Lane Cove Council

Date: 10 December 2018

Re: Submission to Concept State Significant Development Application for the over station development above the Crows Nest Metro Station

2.3 General Arrangement Sections and Elevations
2.3.1 Massing Elevations

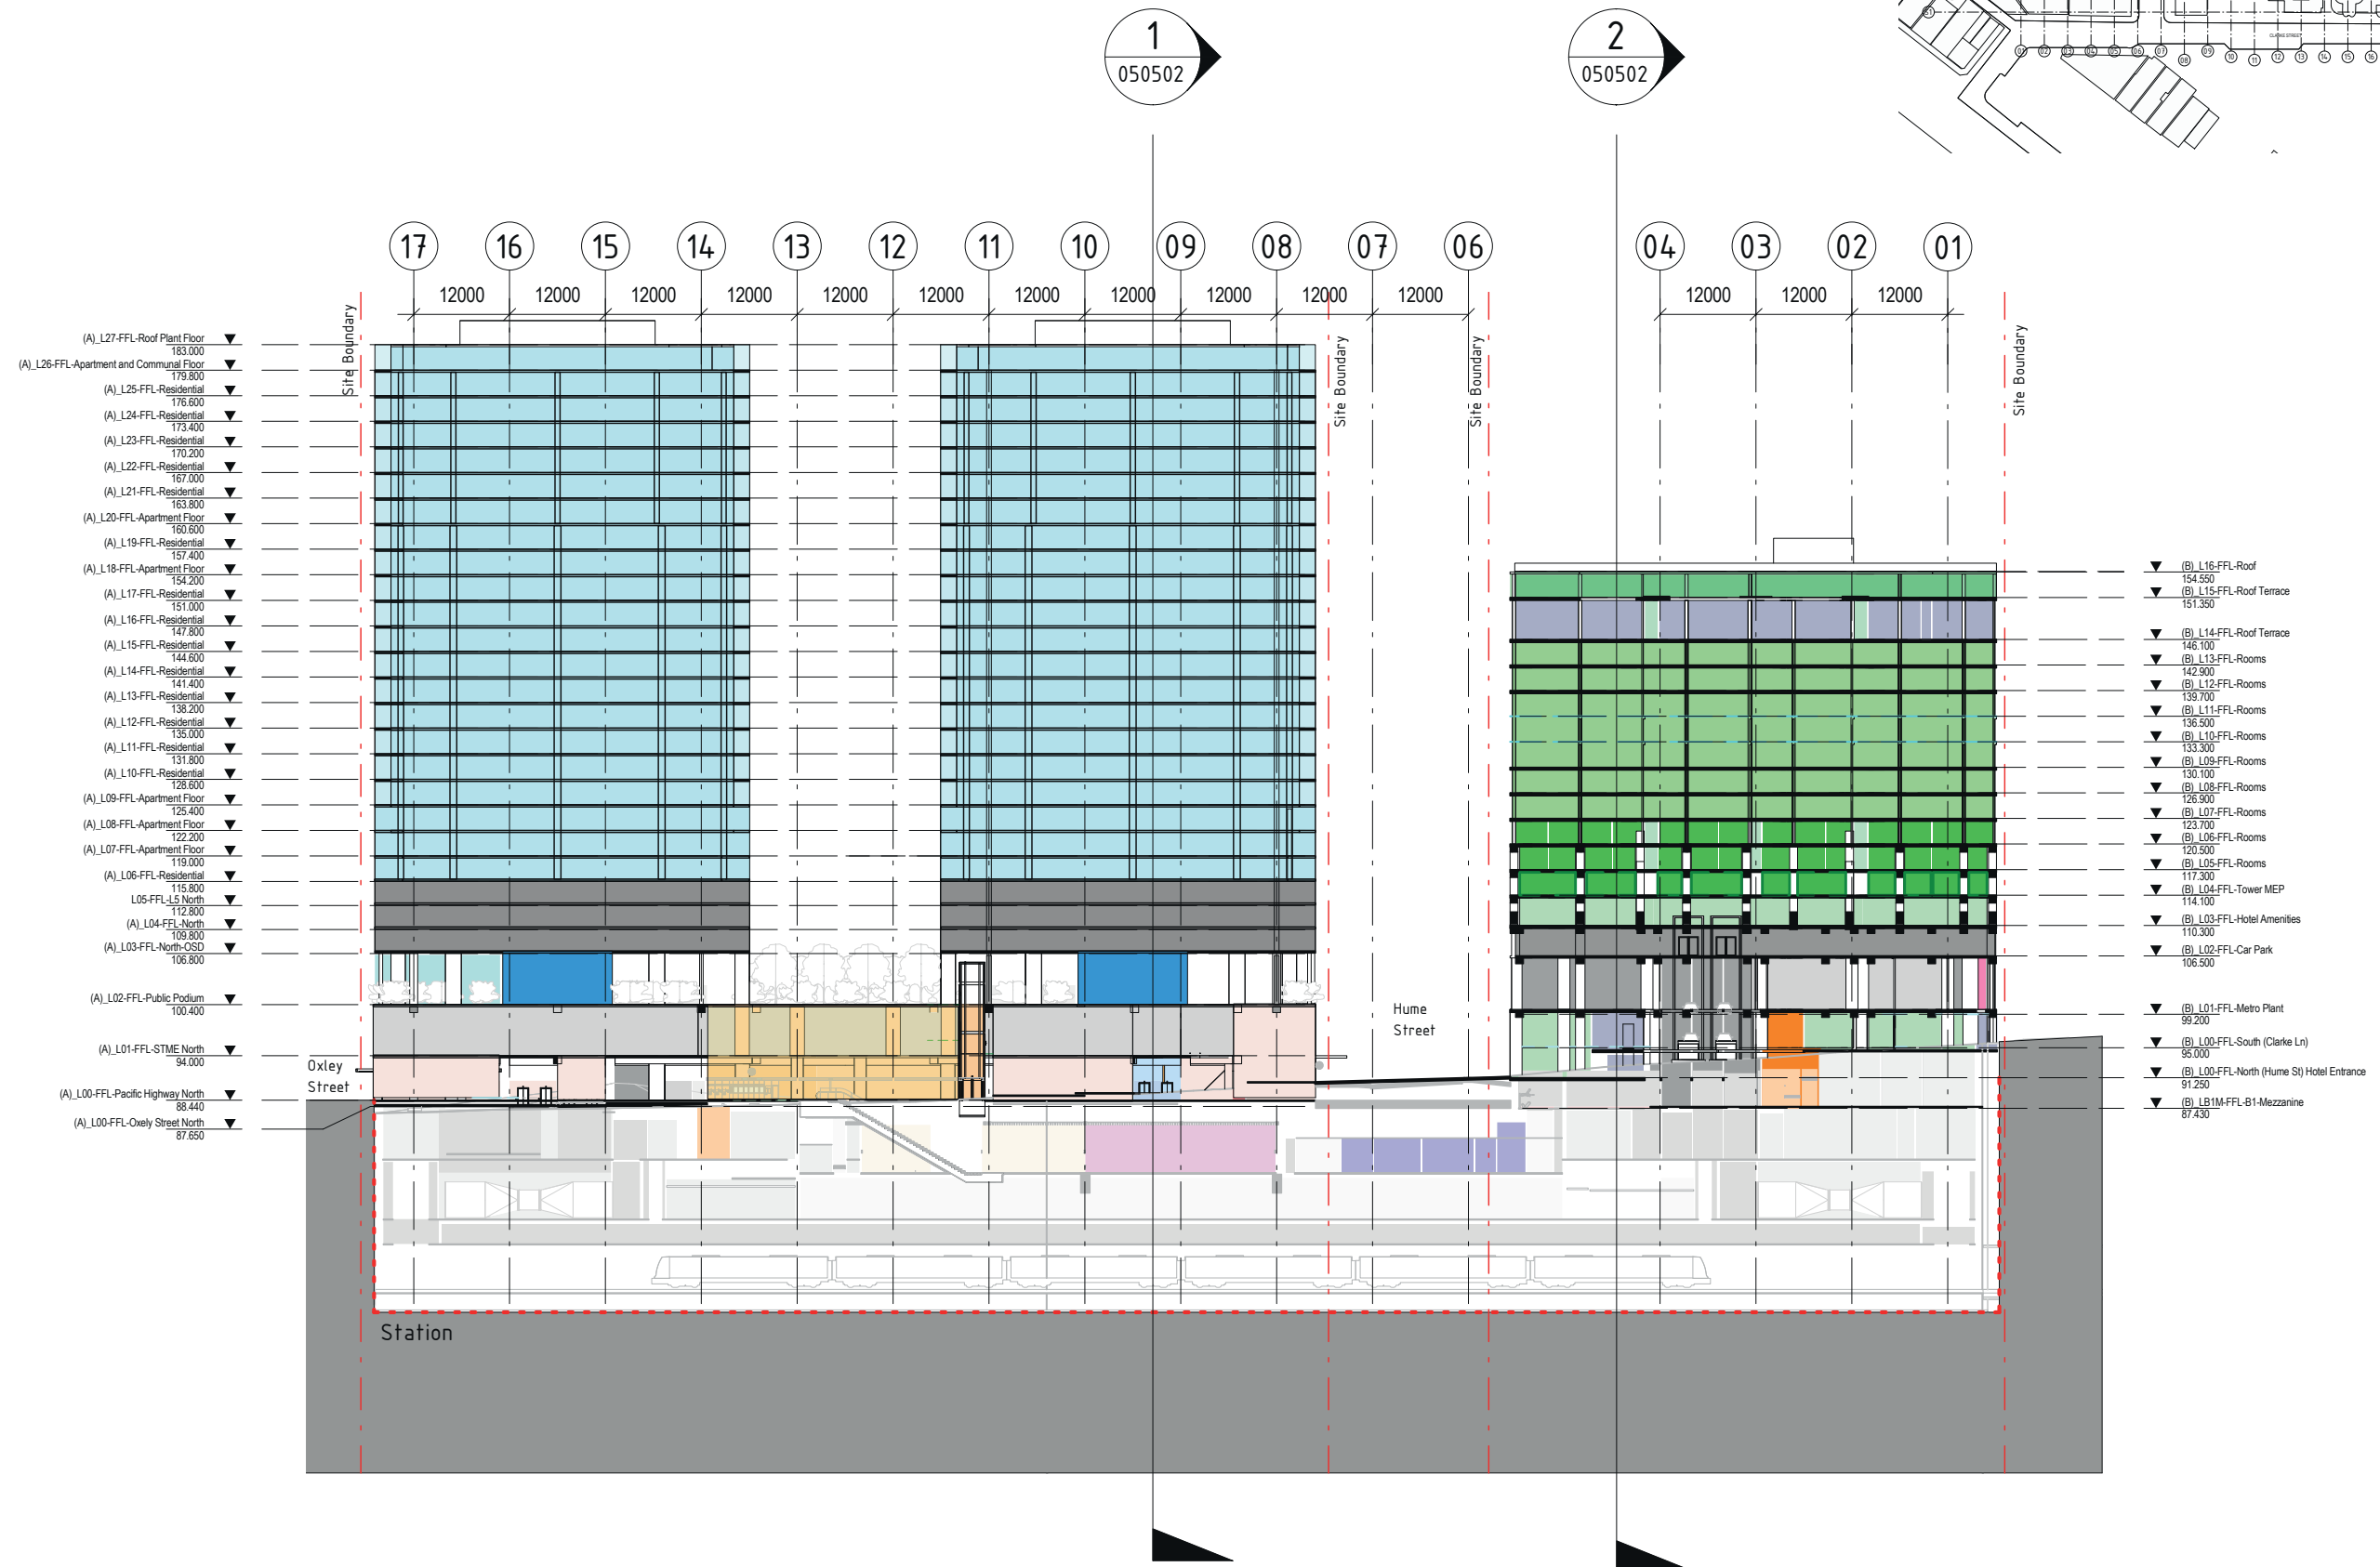
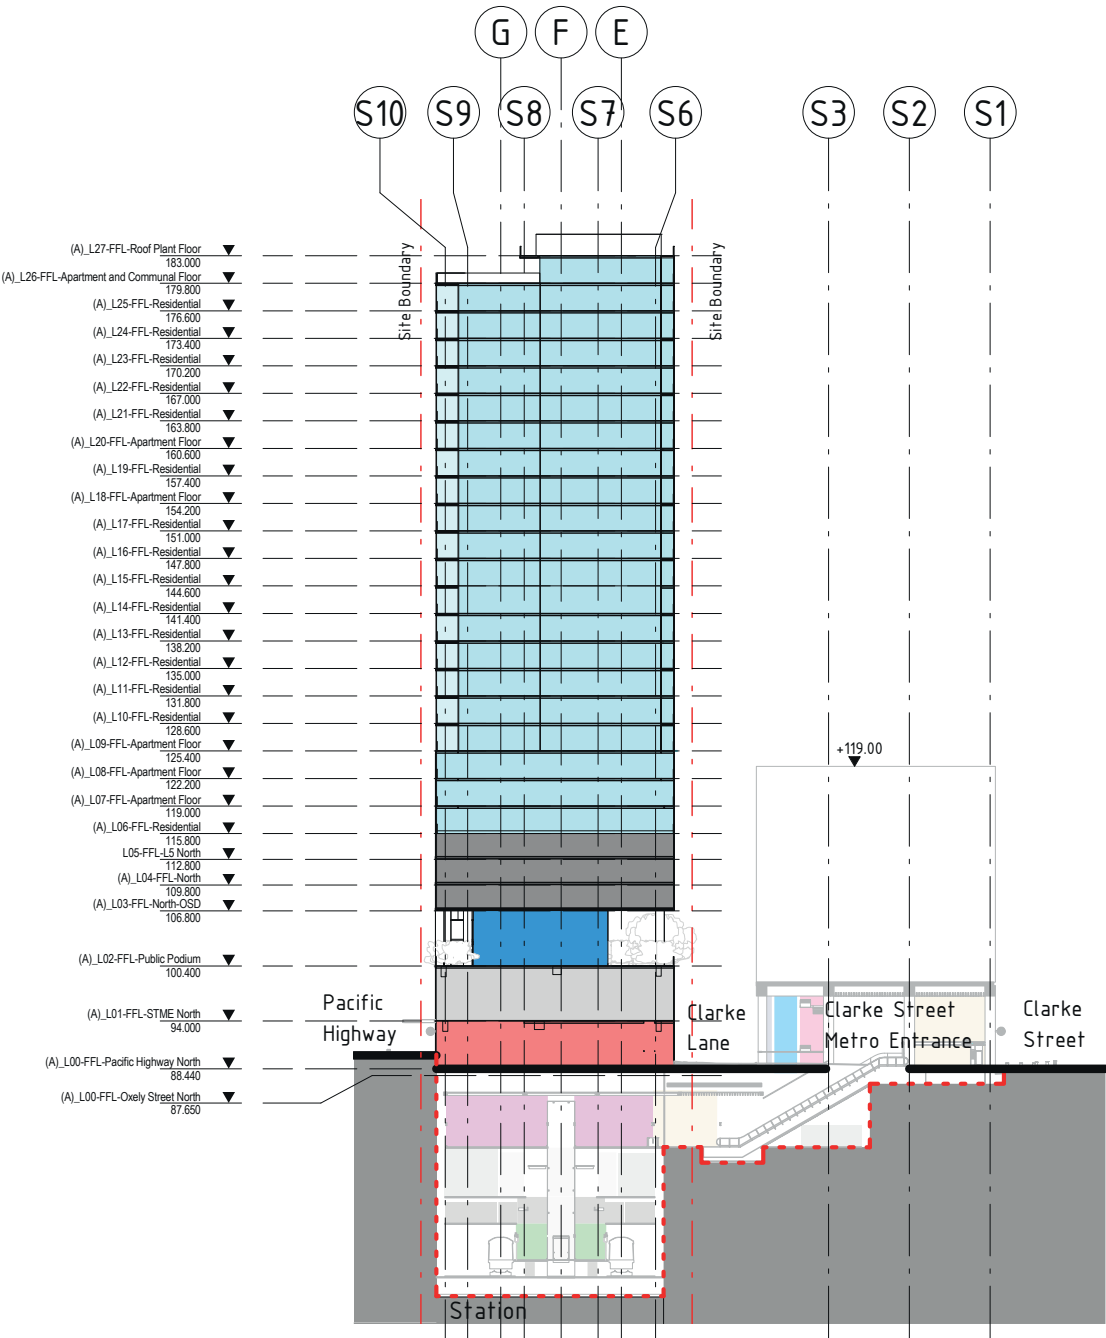
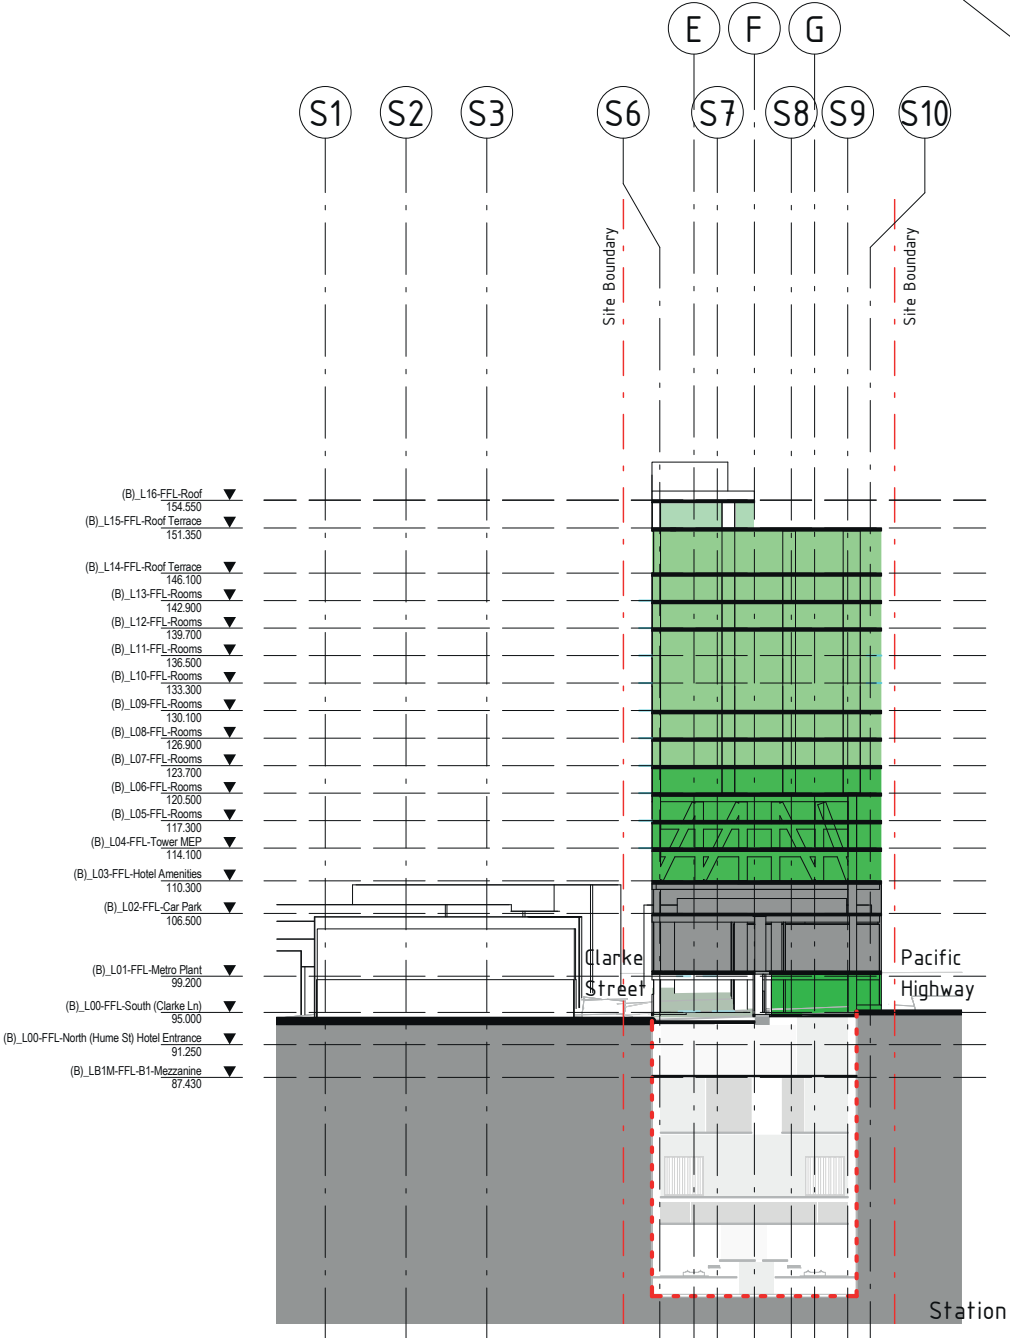
The scale proposed provides minimal transitions to the surrounding areas, and extends the height directly from the St Leonards Commercial centre into the Crows Nest Village precinct, previously stopping at Oxley Street, and while the current imagery demonstrates building envelopes, they do not resolve the transition.

Design Quality guidelines should be updated to include increased upper level setbacks for the proposed residential towers on Site A in order to achieve better transitional built form to the properties in Clarke Lane.

2.1 General Arrangement Plans - Site A
2.1.3 A-L02 Podium Community Roof

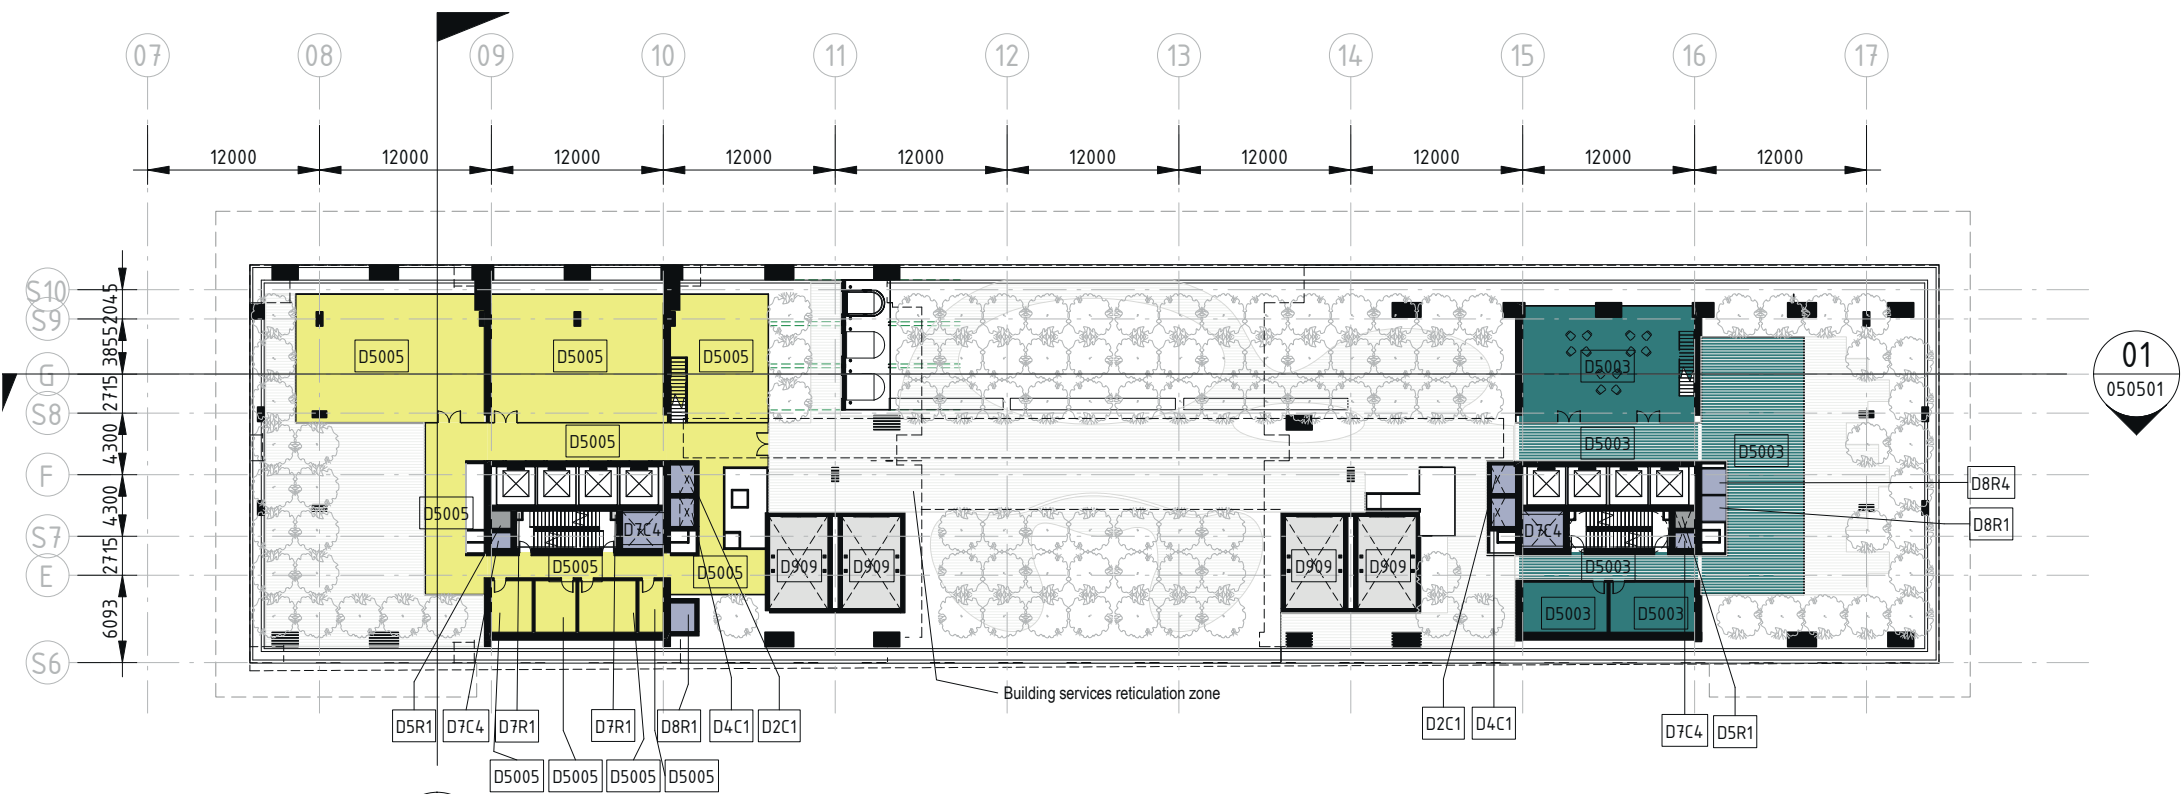
This indicative layout of the proposed social infrastructure is shown in Appendix F – Urban Design Report, and contains a ‘community centre, child care facility and a roof garden’ (see diagram below).

In terms of the proposed land uses, Lane Cove Council supports additional social infrastructure within the precinct that services the needs of all 3 Councils (i.e. North Sydney, Lane Cove and Willoughby). The EIS also states that this land mix *“forms the basis for the assessment of the expected impacts of future development and is conceptual only. The final land use composition will be the subject of further detailed environmental assessment as part of the future detailed SSD Application”* (page 100 of EIS).

Given the draft findings of the *Social Infrastructure and Open Space* study, and the recent approval of a branch library as part of the JQZ development, it is recommended that the Crows Nest Metro site incorporate either an additional central or branch library into its application.
